TII26-136785

Re: Strategic Infrastructure Development Application for the Littleton Wind Farm comprising of 11 no. turbines and all associated works, Co. Tipperary

ACP case ref. PAX92.324370

<b>TITLE:</b>	Grid Connection Route
<b>PROJECT:</b>	Littleton Windfarm
<b>FIGURE NO:</b>	4.3.a
<b>CLIENT:</b>	Littleton Wind Farm DAC
<b>SCALE:</b>	1:57,000
<b>REVISION:</b>	0
<b>DATE:</b>	31/03/2026
<b>PAGE SIZE:</b>	A3

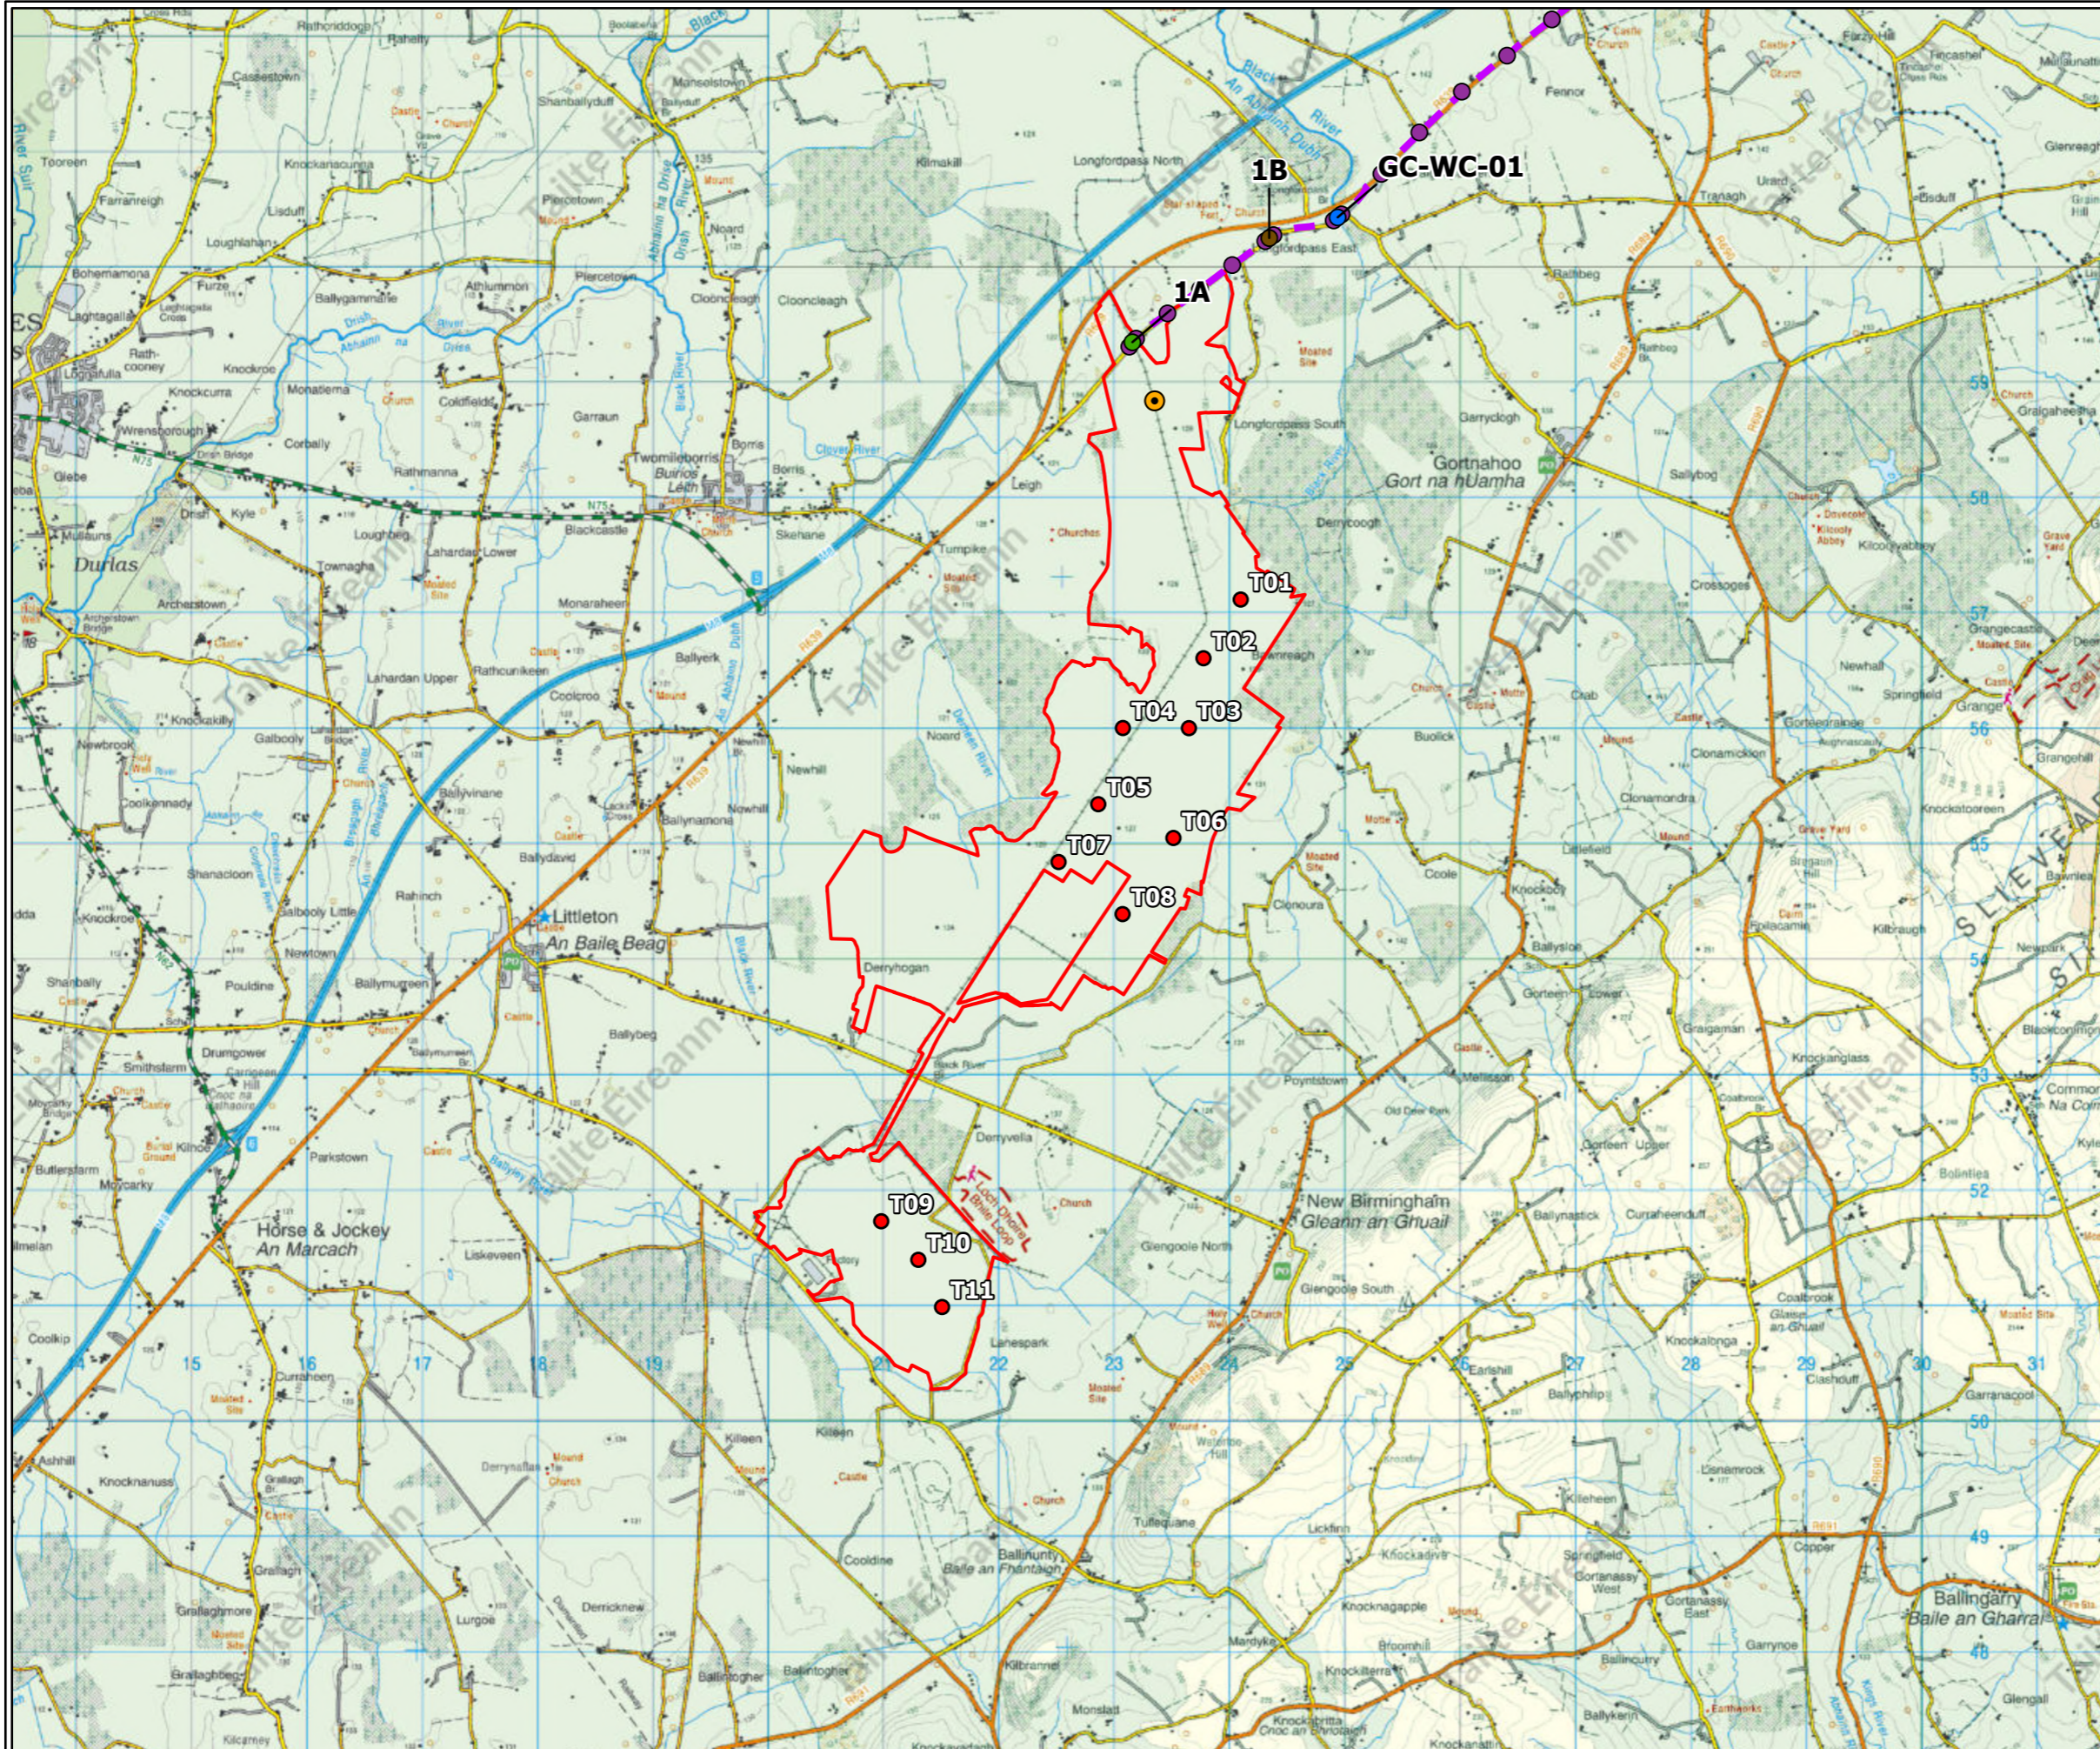
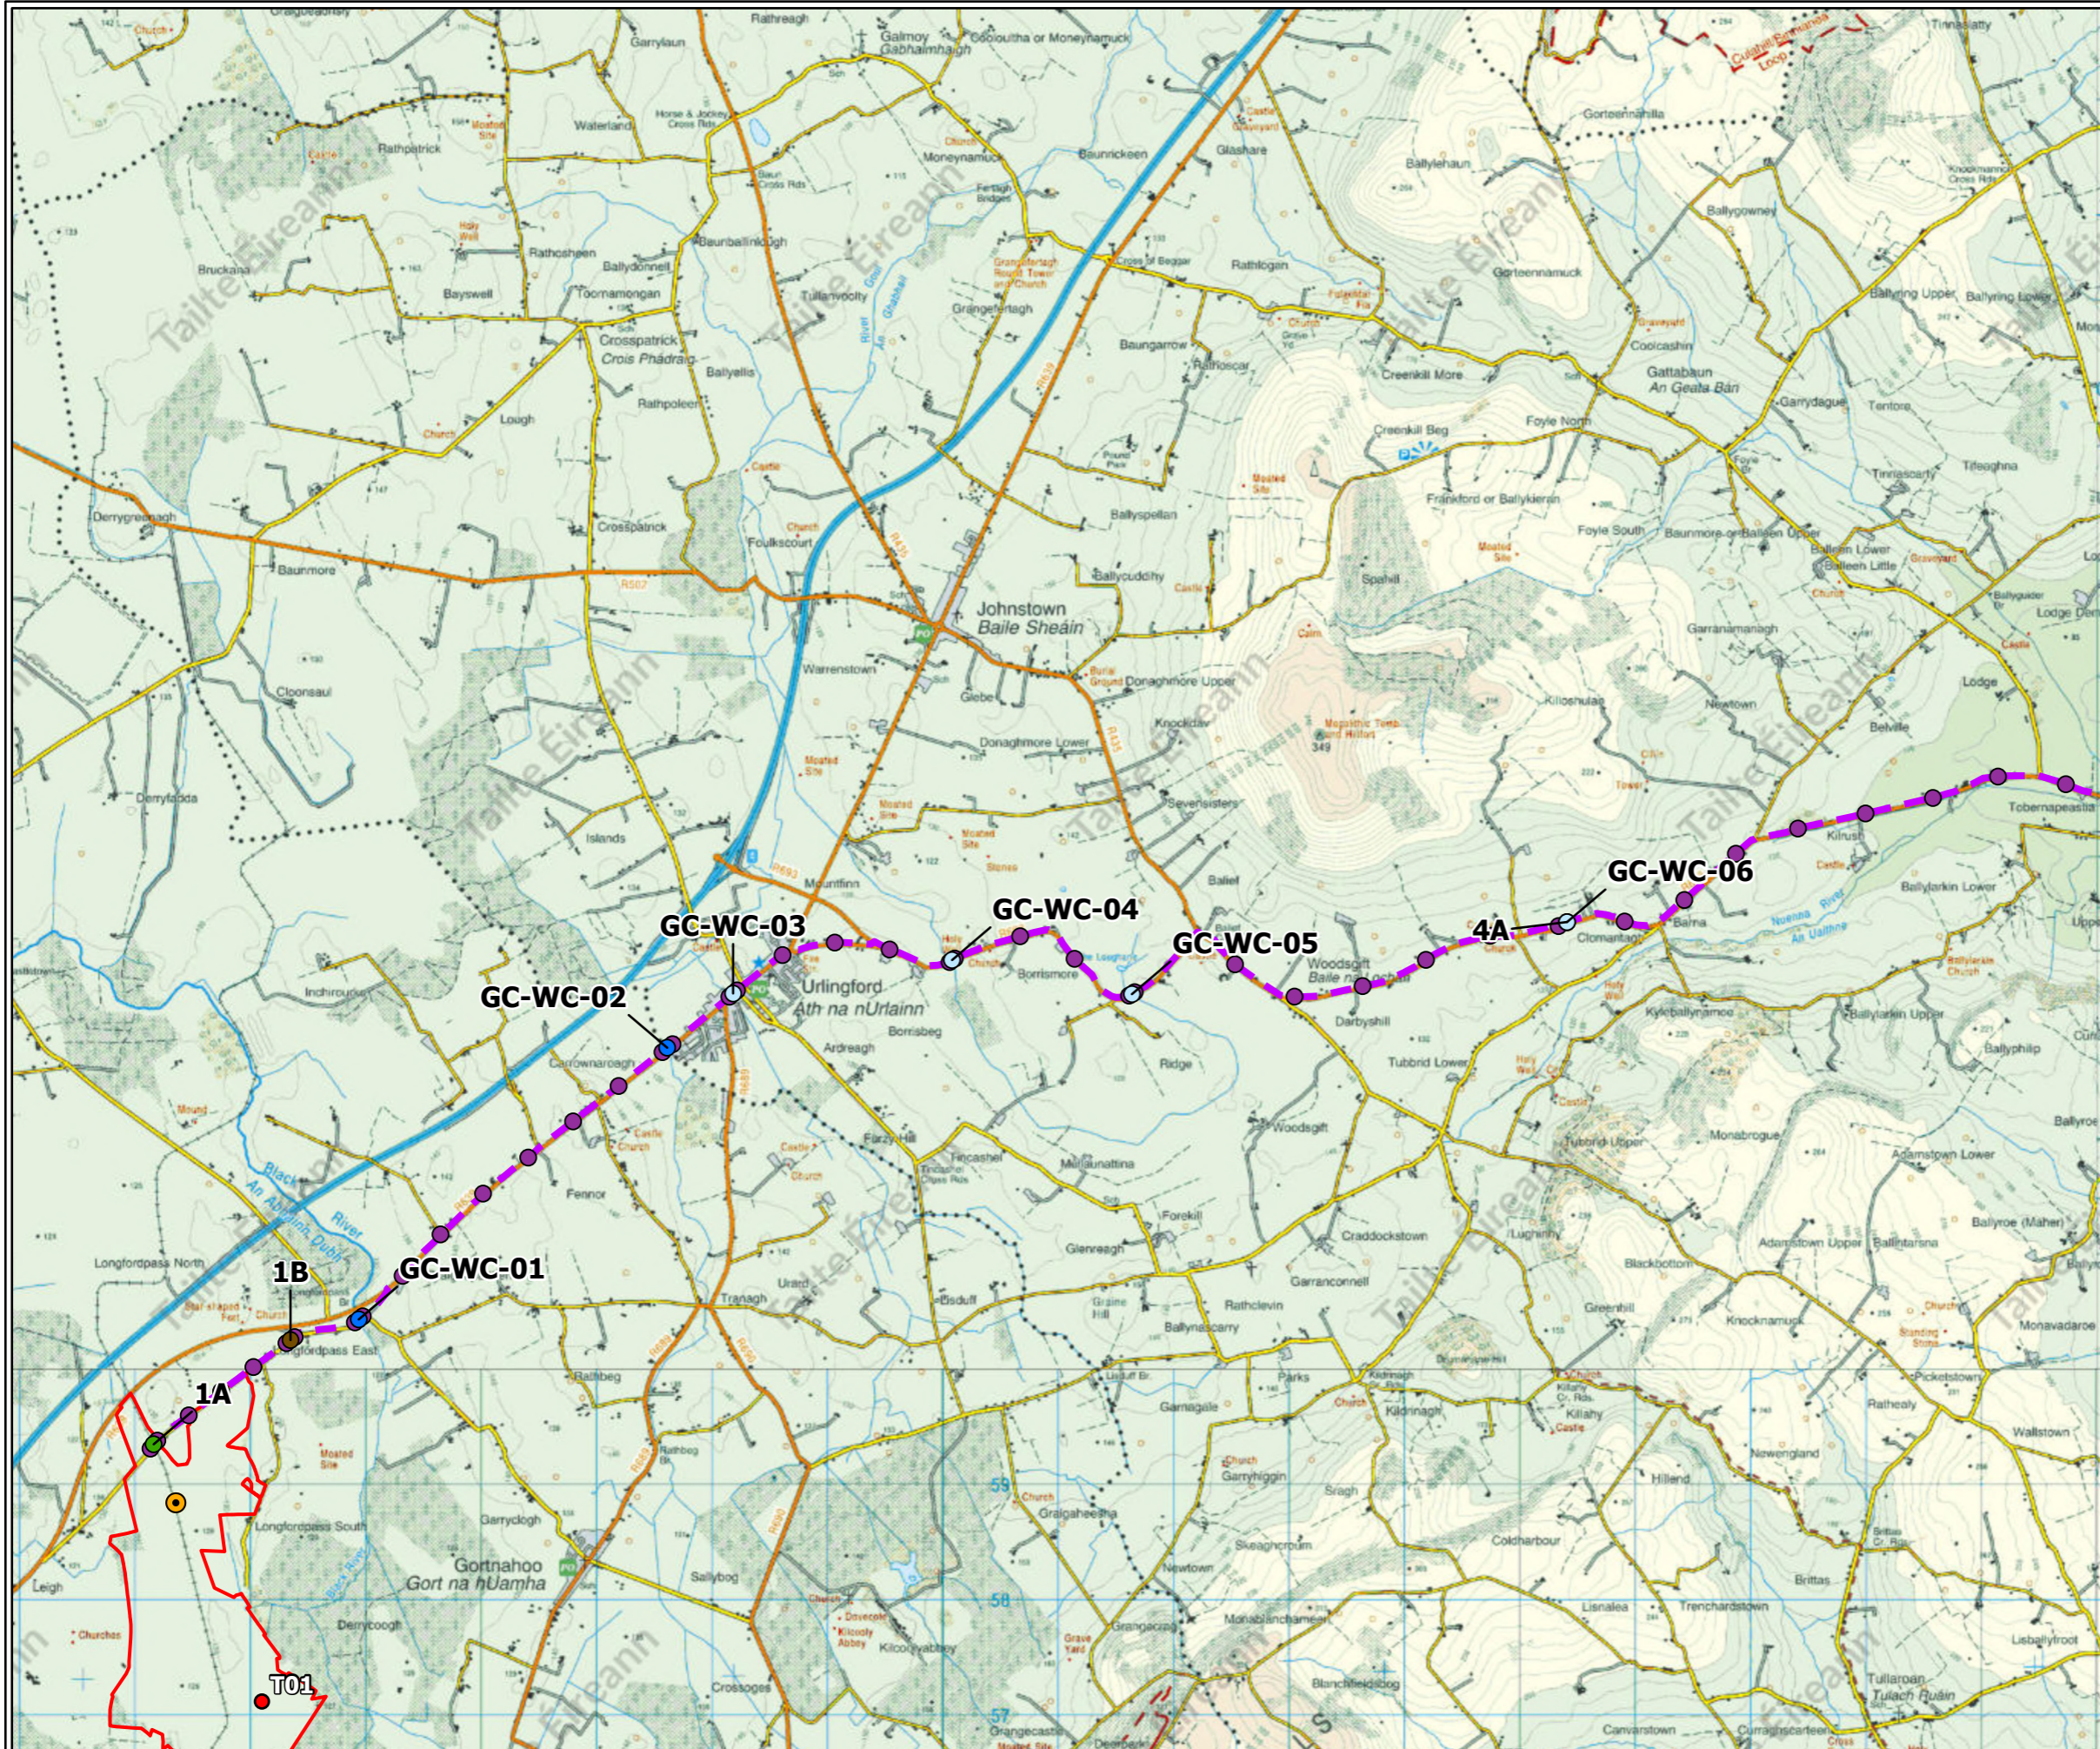
The grid connection routing to the Ballyragget 110kV substation details approx. 1km of grid connection routing along the N77 and possibly 3 no. joint bays in the N77 road reservation. The Commission will be aware of a number of renewable energy development proposals grid connections to the Ballyragget 110kV substation with routing identified along the same sections of the N77, national road. For example, Kilkenny County Council planning application references 23/60248 and 25/60003 refer.

Clarification may be necessary to demonstrate that proposals can all be accommodated in the finite road space, where proposed grid connection routes interact. Opportunities to co-ordinate proposals in that regard, to ensure deliverability and to mitigate impact to the road network, may be available.

Having regard to the measures identified in CAP24 and the information in relation to grid routing included in the subject application, TII recommends that the applicant demonstrate and the Commission be satisfied that the proposed grid routing in any subsequent application represents the optimal routing solution.
